## REFUSAL OF PLANNING PERMISSION

APPLICATION NO. 2019/1102

**Proposal** Erection of detached triple garage

**At** 54 Jebb Lane, Haigh, Barnsley, S75 4BU

Site Plan (1:500)

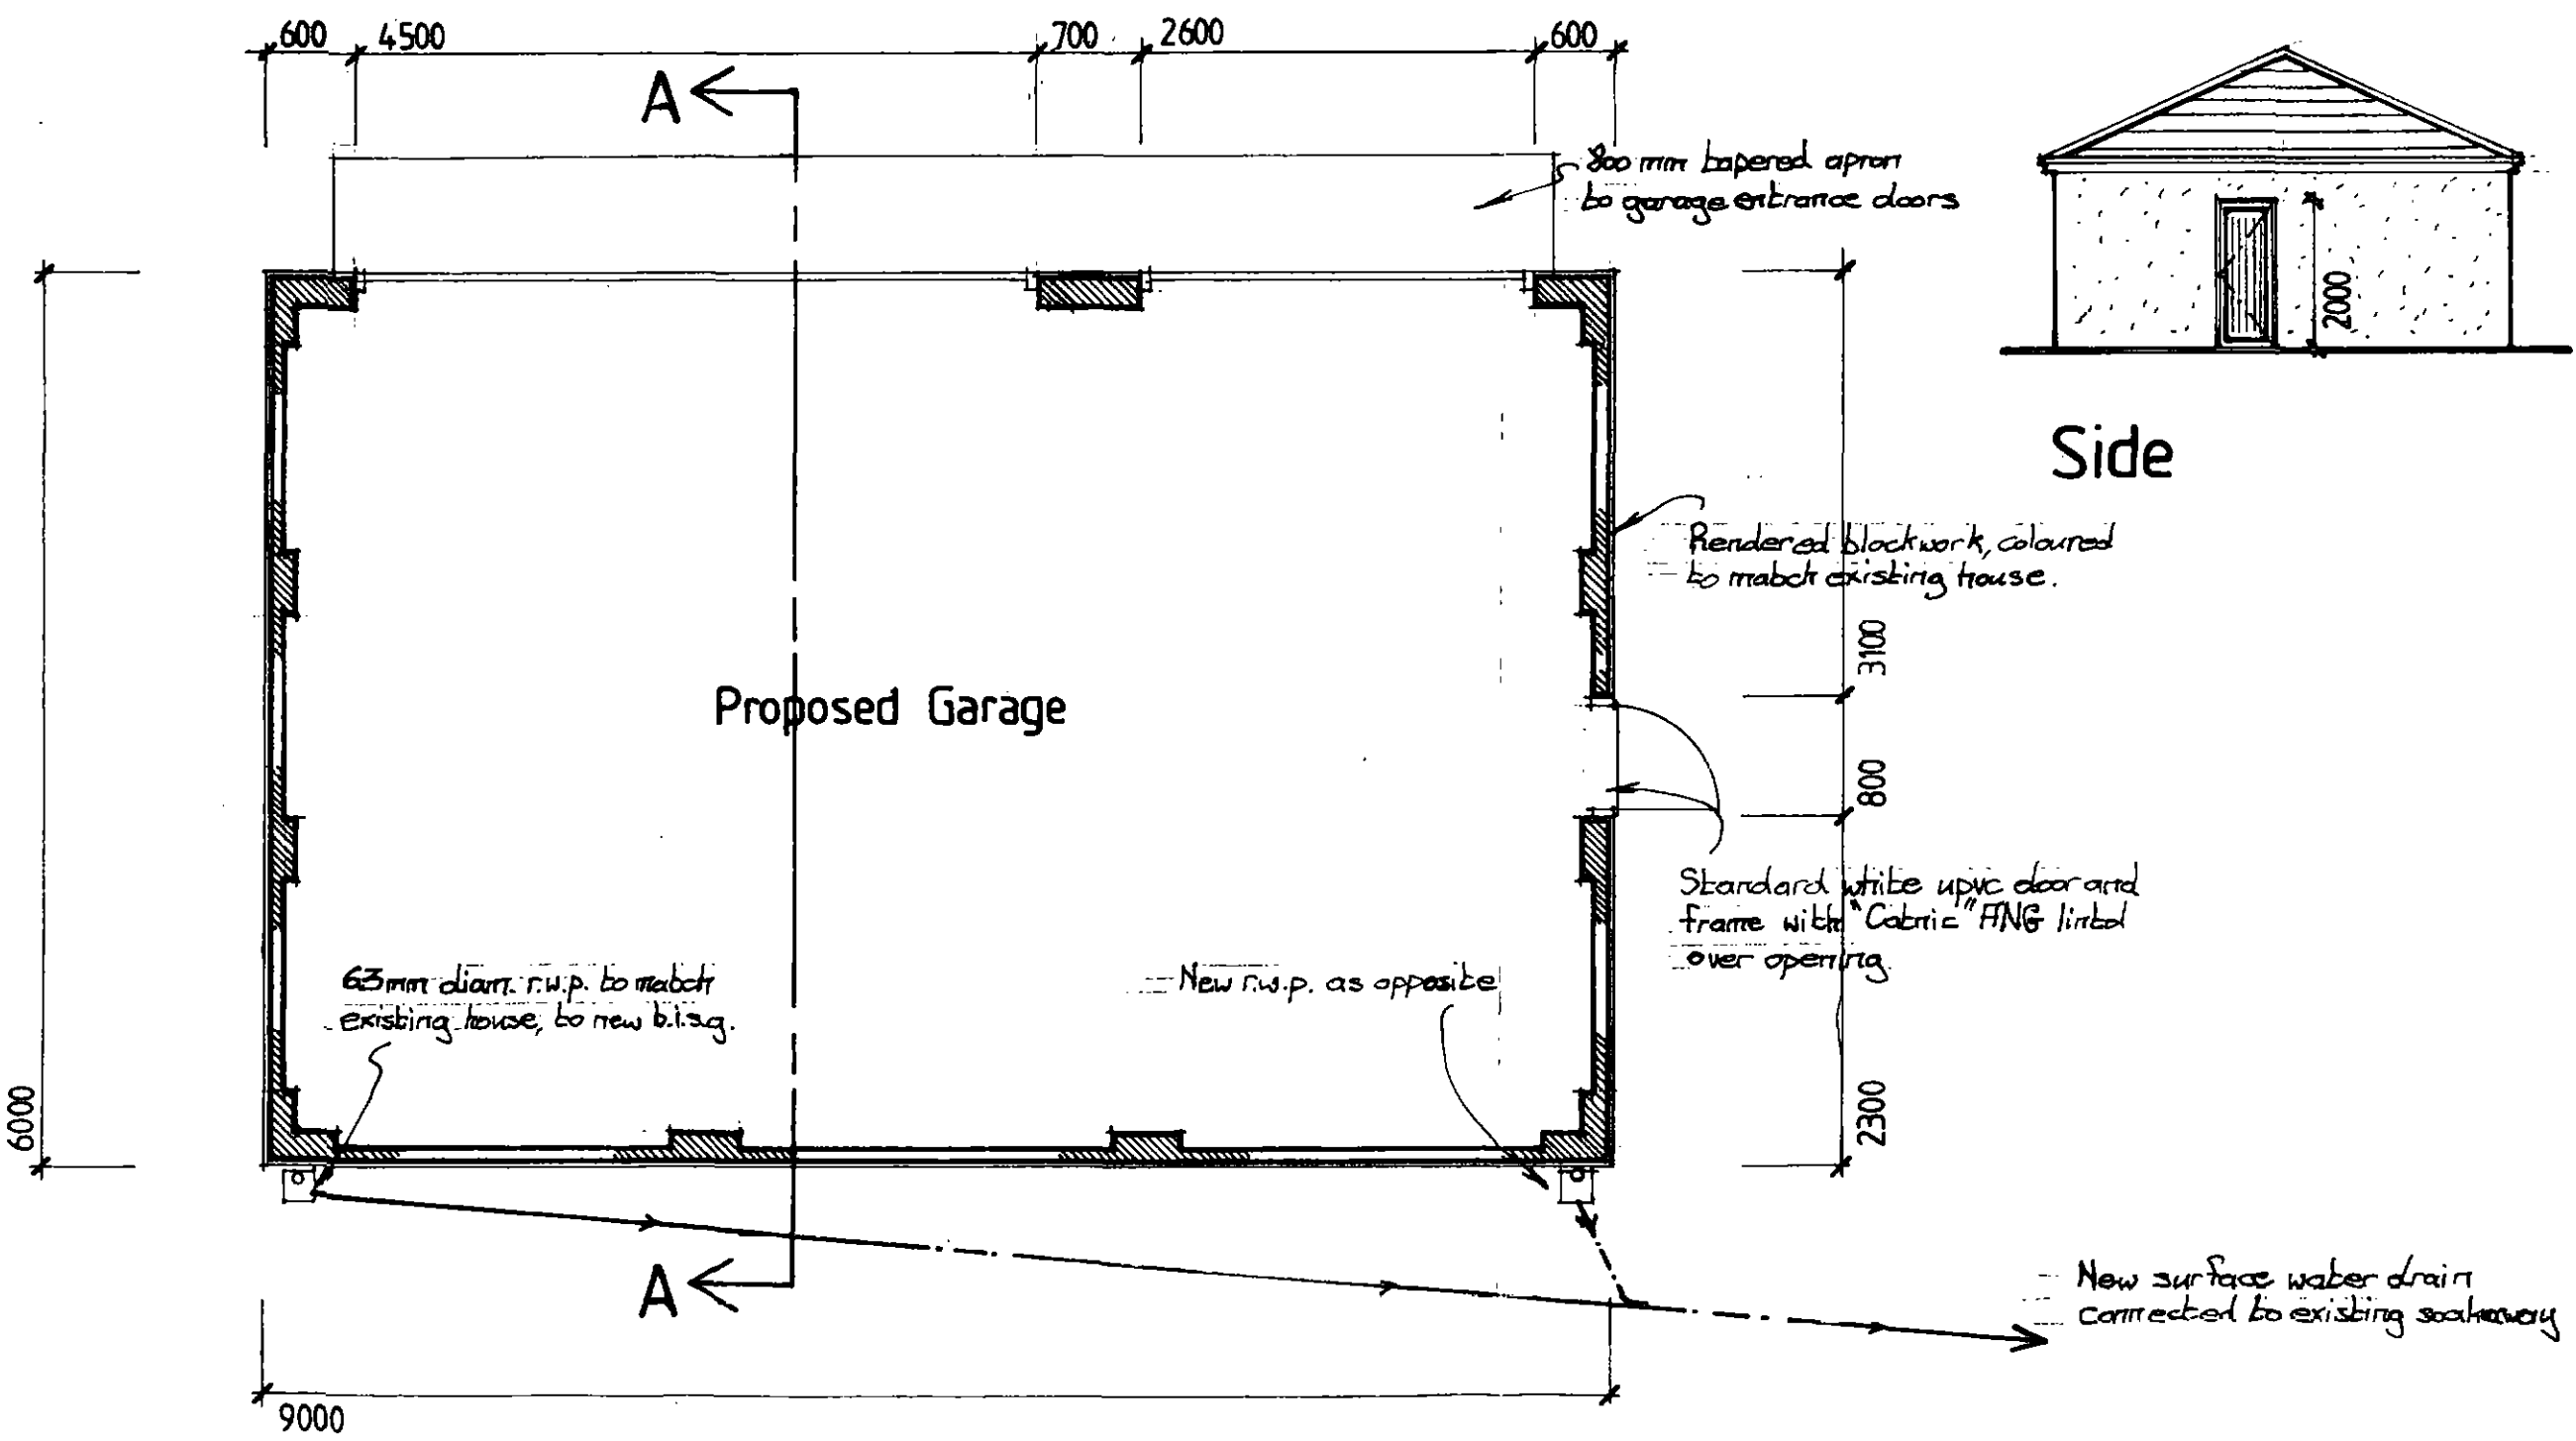
1	In the opinion of the Local Planning Authority, the proposed garage, due to its insensitive siting between the house and the road, would appear as an overly prominent feature in the Jebb Lane street scene, at odds with the predominantly open character and nature of the area, to the detriment of visual amenity and contrary to local plan policy D1: High Quality Design and Place Making, National Planning Policy Framework sub-paragraph 127, and SPD: House Extensions and other Domestic Alterations.
2	The site lies within the Green Belt in the Local Plan and the proposed development would be contrary to Local Plan policy GB2: Replacement, extension and alteration of existing buildings in the Green Belt and paragraph 145 in the NPPF in that the total size of the proposed and previous extensions would exceed the size of the original dwelling which in the opinion of the Local Planning Authority would result in disproportionate additions to the building with no very special circumstances existing that would justify the granting of planning permission in this instance.

2	In the opinion of the Local Planning Authority, the proposed garage would lead to harm to the setting of nearby heritage asset by virtue of its overly prominent location between the dwelling and the road and the external materials which are not in keeping, and at odds with, the nearby listed buildings to the detriment of the Historic Environment and contrary to Local Plan policies HE1: The Historic Environment and HE3: Developments affecting historic buildings and paragraphs 190, 193, 194 and 196 in the National Planning Policy Framework.
